Our Ref: LU/246/19/NMA
Your Ref:

Application for A Non-material Amendment Following a Grant of Planning Permission

Development Non-material amendment following the grant of reference LU/59/19/PL for installation of an ATS cart canopy, re-provision of the existing cycle shelter and re-provision & relocation of the existing smoking shelter from north-east corner of Building 5 to south-east corner of Building 5.

Location Land at Watersmead Business Park Worthing Road Littlehampton

ATS CART CANOPY PLAN
1 : 50

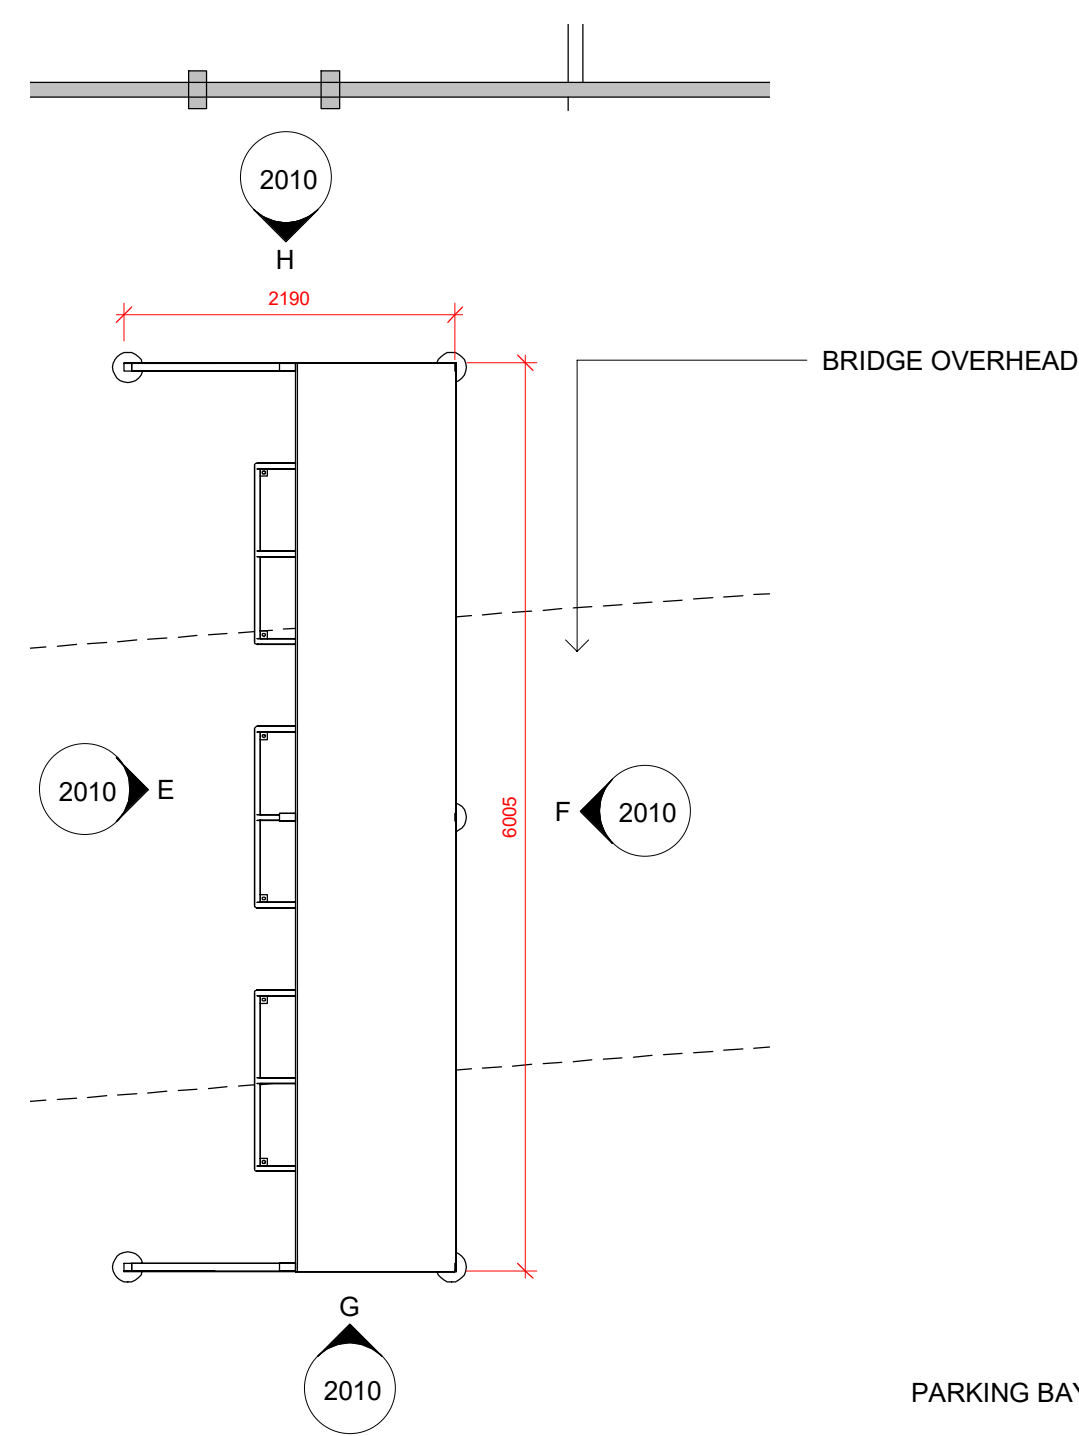
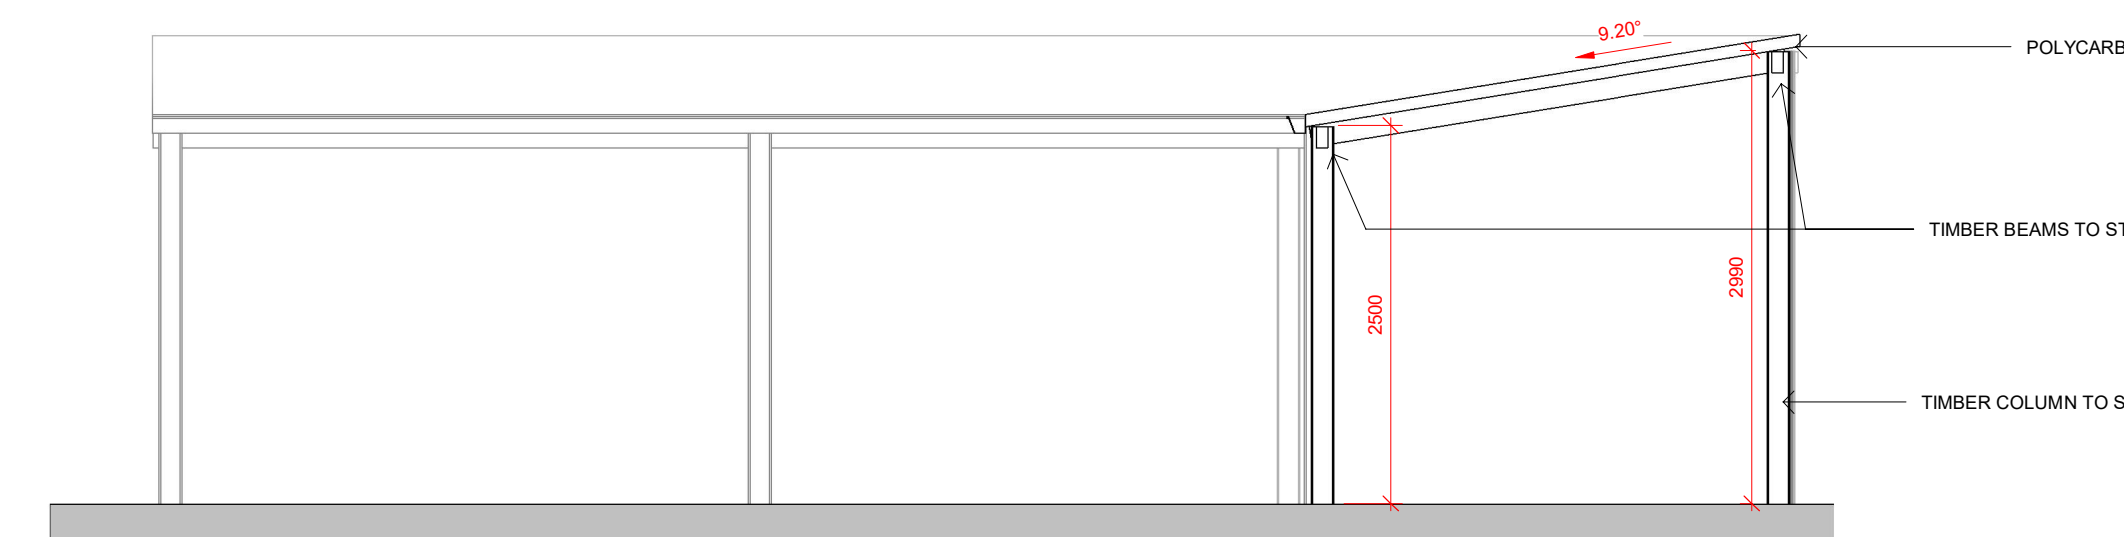
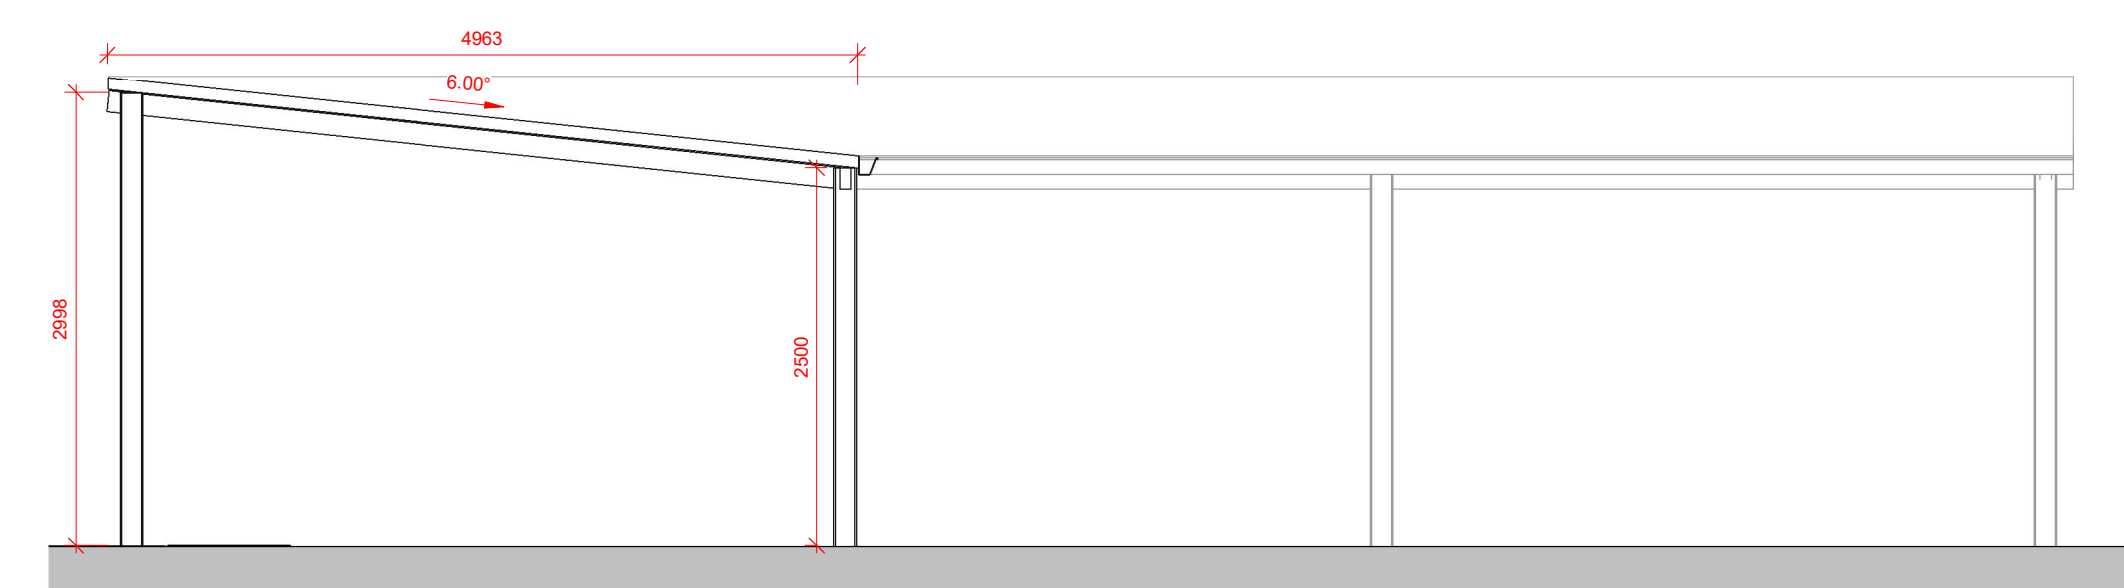
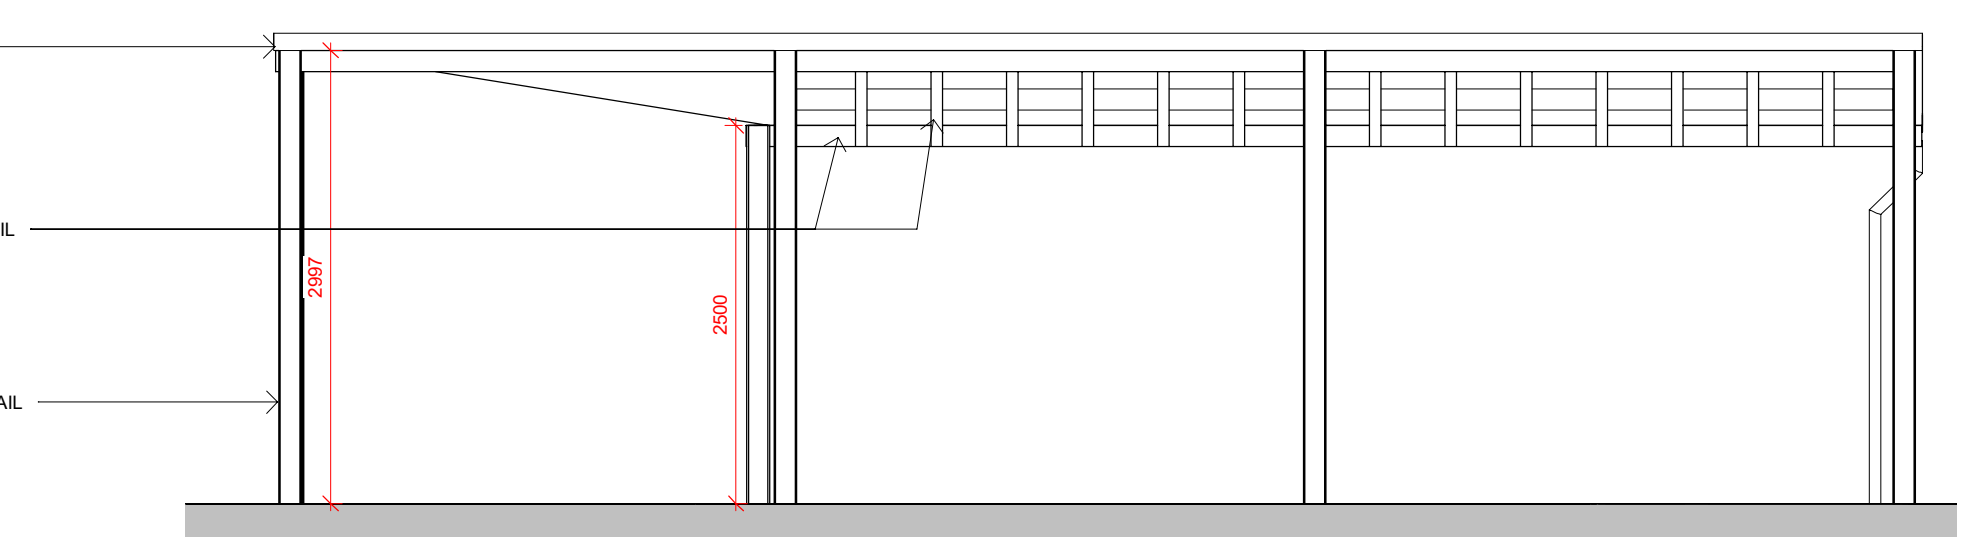
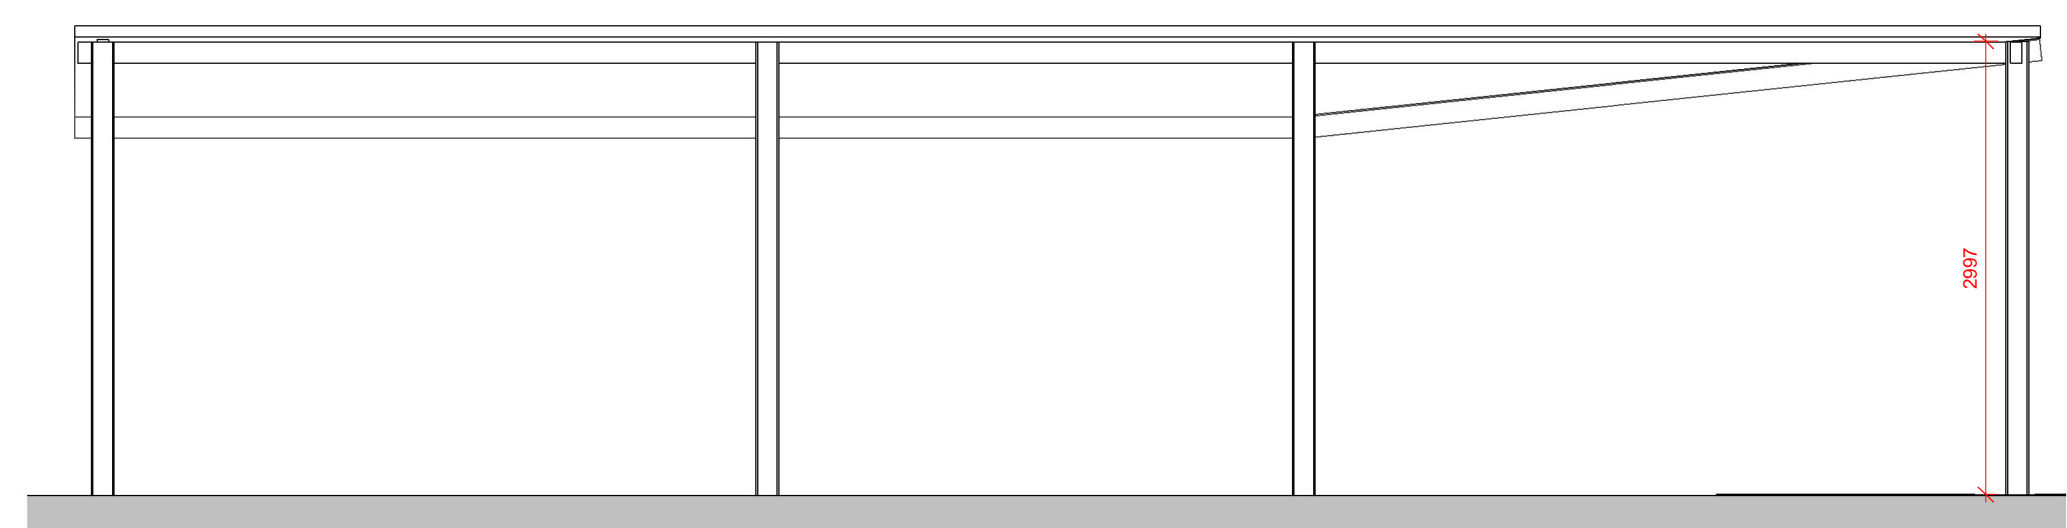
There are no apparent details for the proposed ATS cart canopy.

SMOKING SHELTER DETAILS PLAN
1 : 100

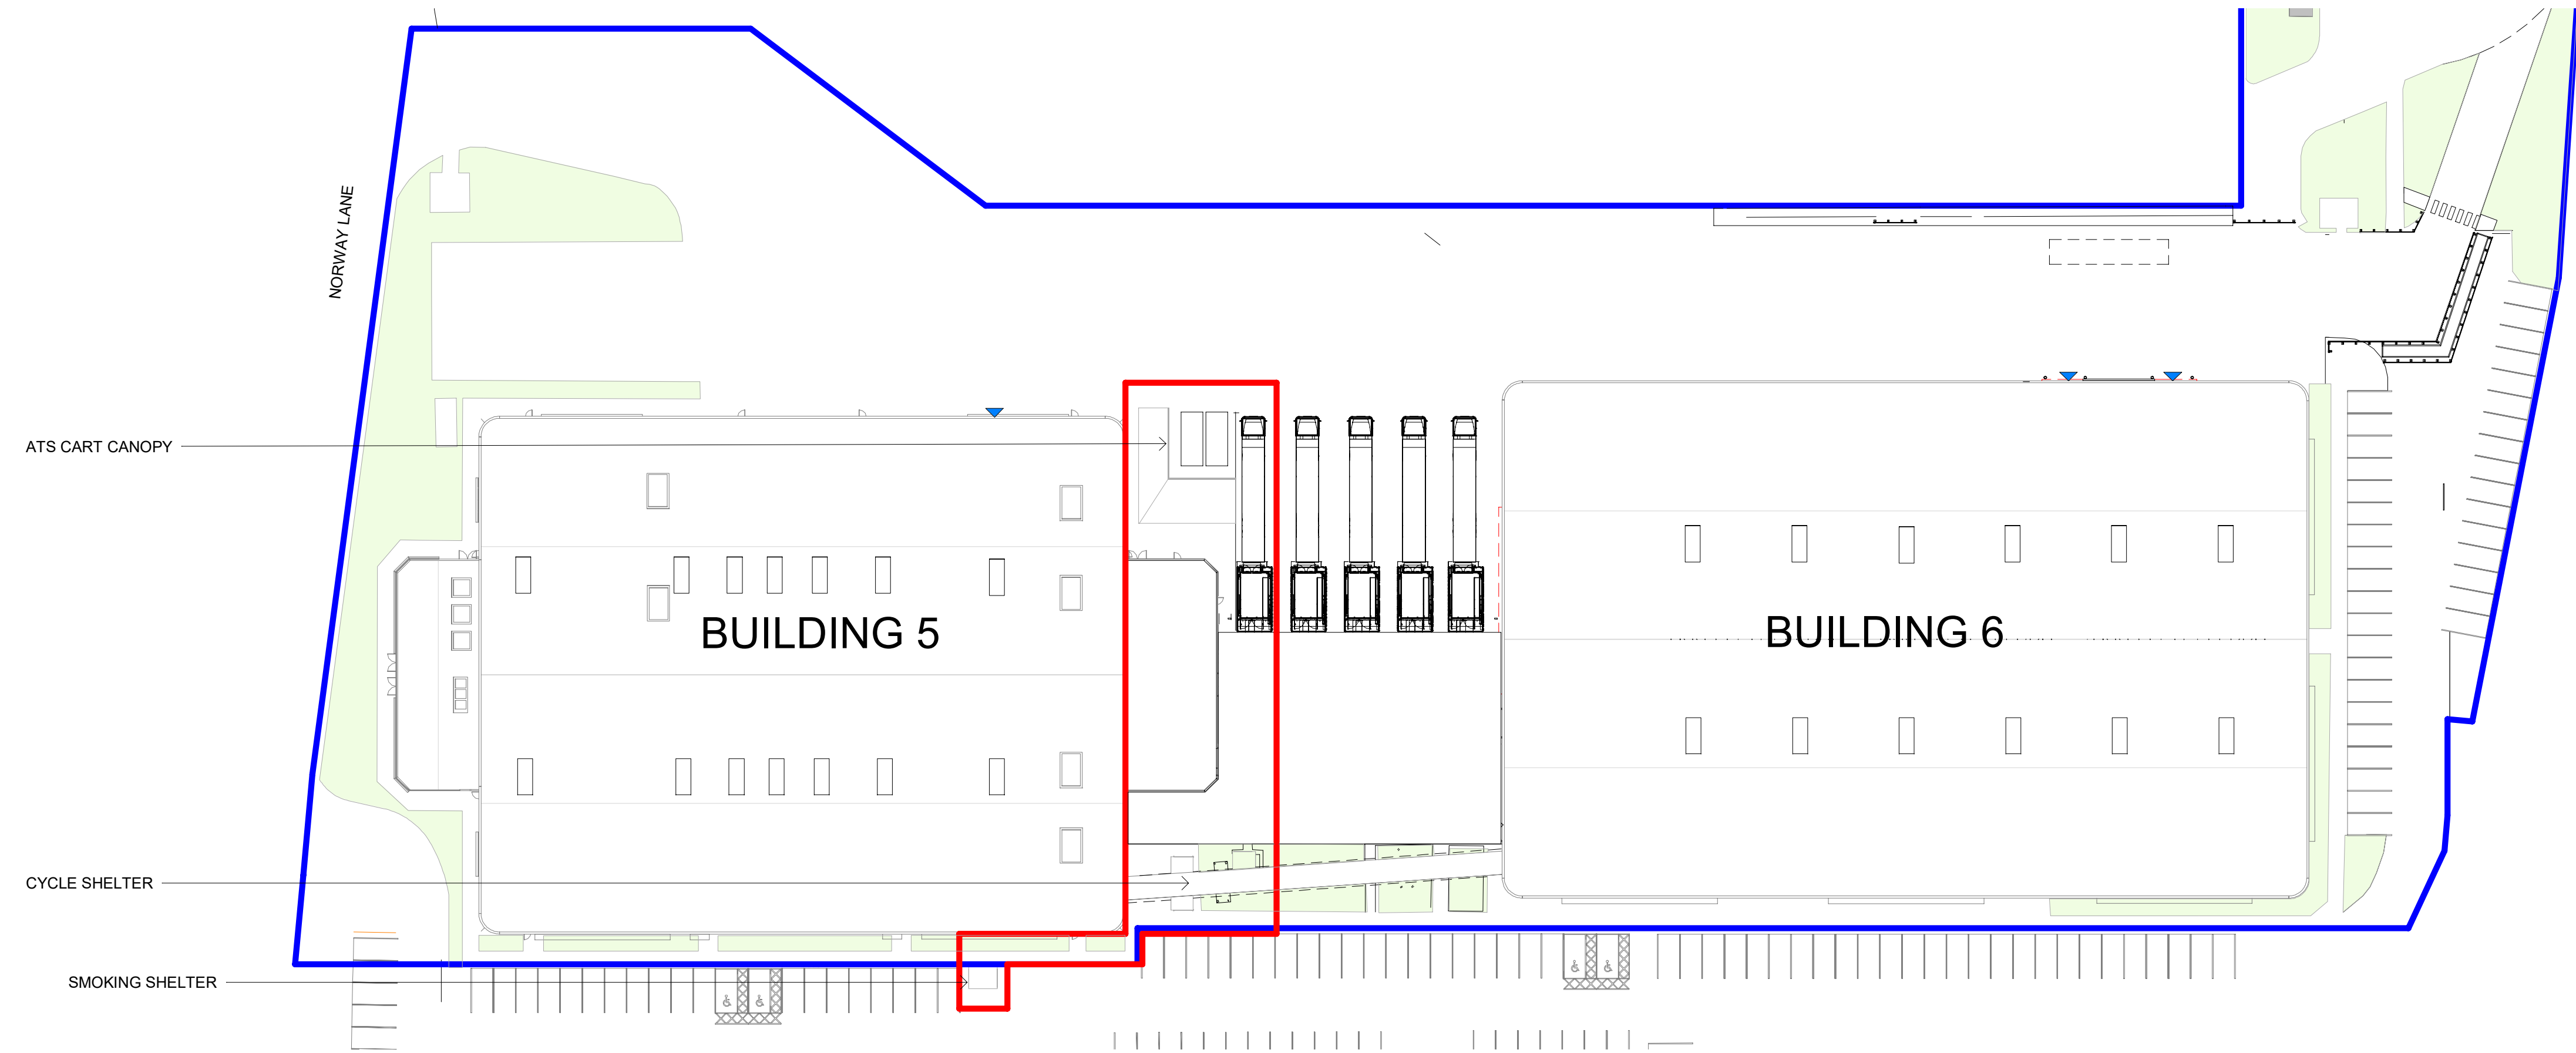
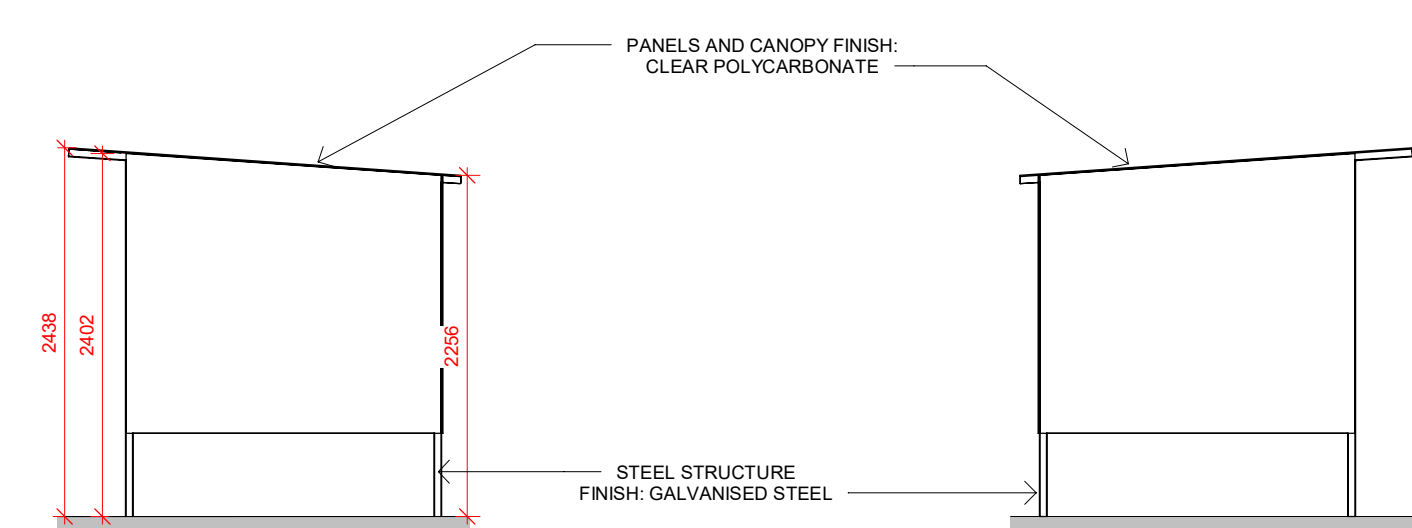
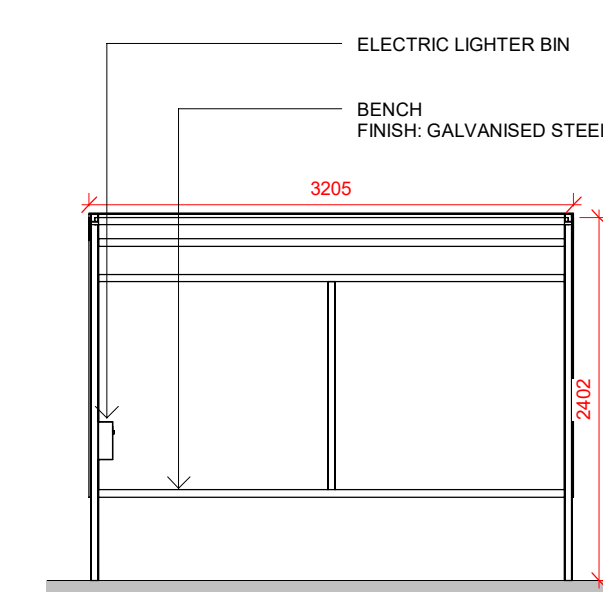
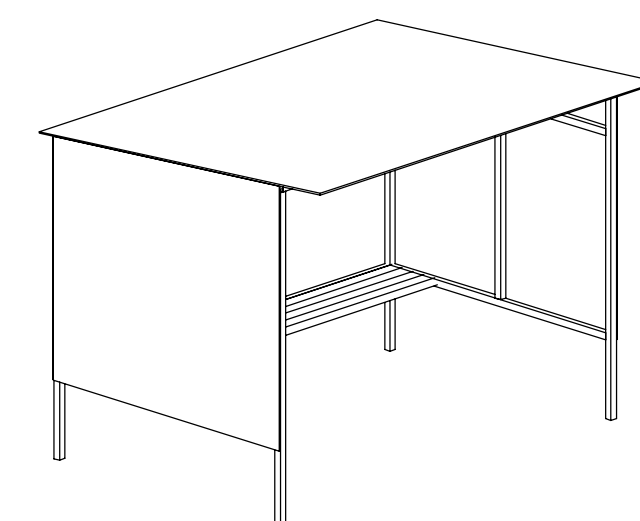
The re-provision and relocation of the smoking shelter is unacceptable as a Non-Material amendment as it is not within the approved red edge, therefore a new planning application will be required.
